Our Ref: AL/123/18/PL

**Town & Country Planning Act 1990 (as amended)
Town and Country Planning (Development Management Procedure) (England) Order 2015
Application for Planning Permission**

Development Two storey extension to provide an additional 8 bedrooms.

Location Westergate House Denmans Lane Fontwell

1 Ground floor Demolitions
1 : 100

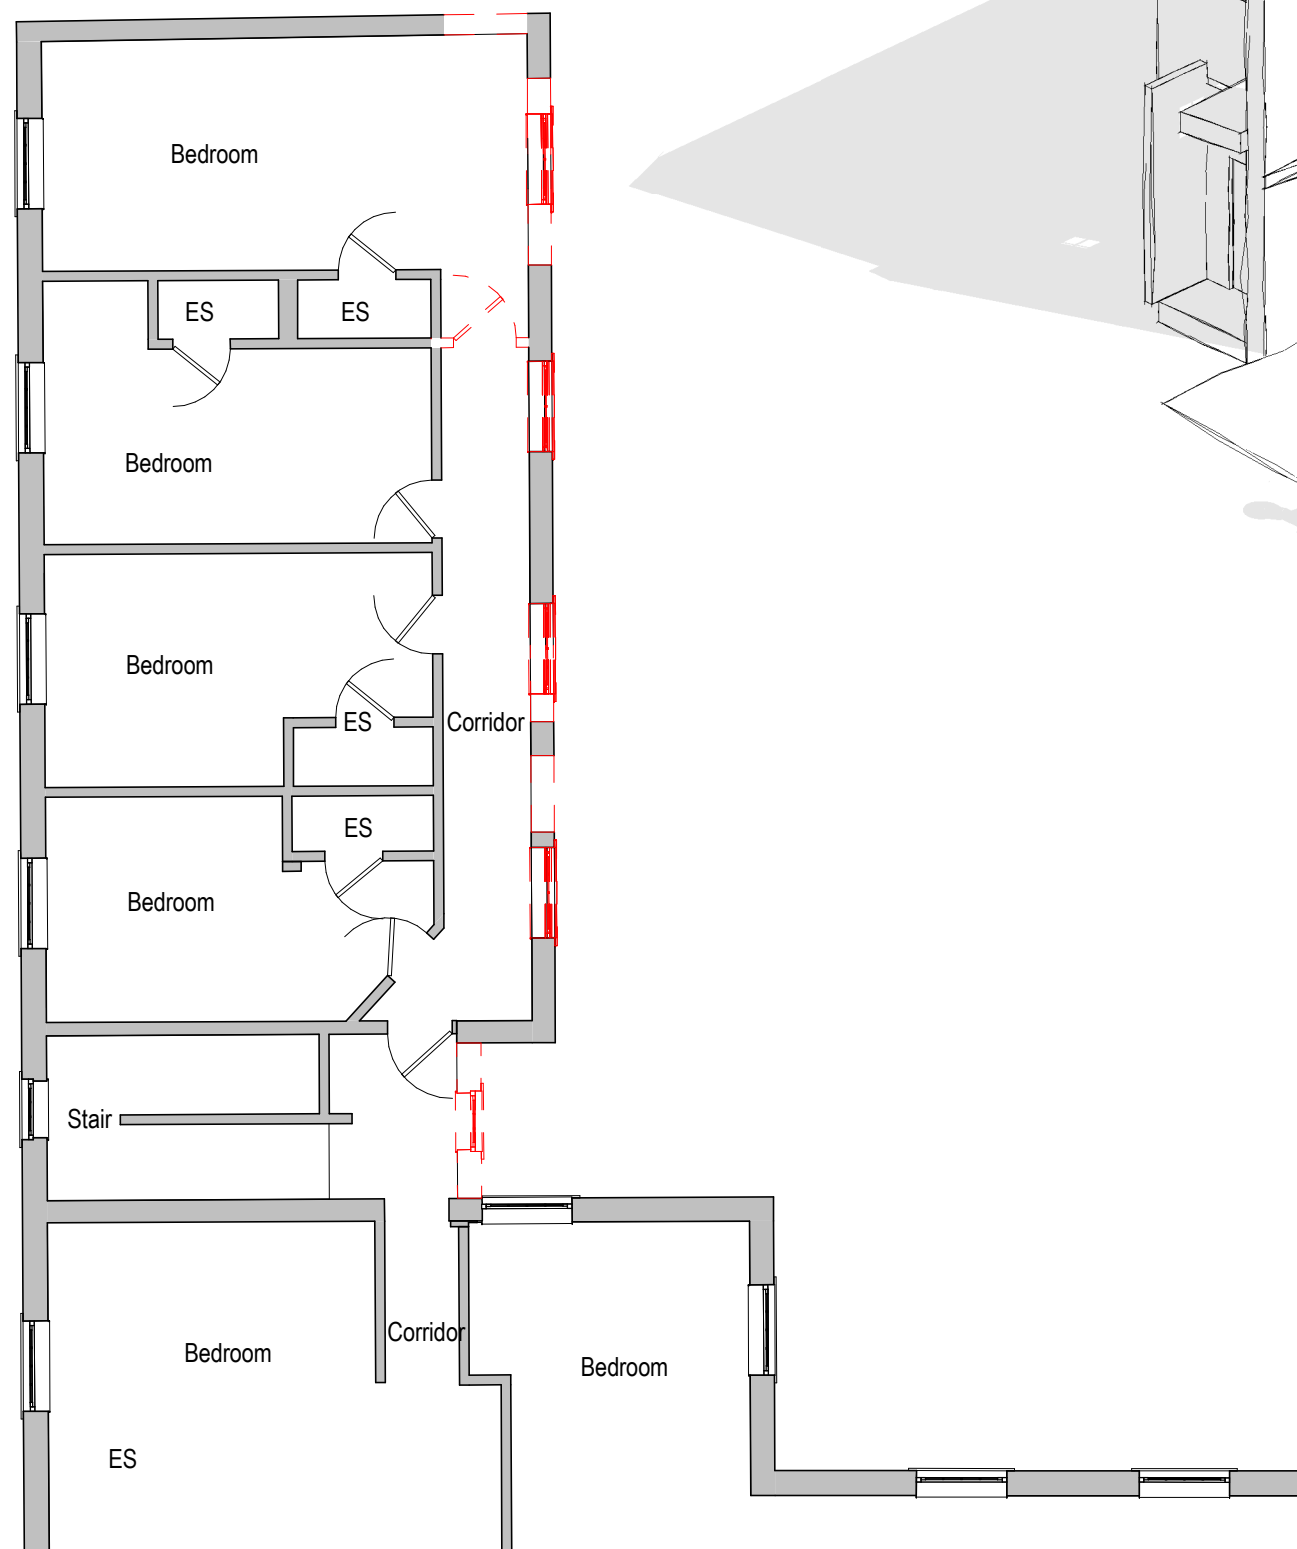
The existing west ground floor plan and elevation do not accord. Please amend accordingly.
Foul and Surface Water Drainage Statement
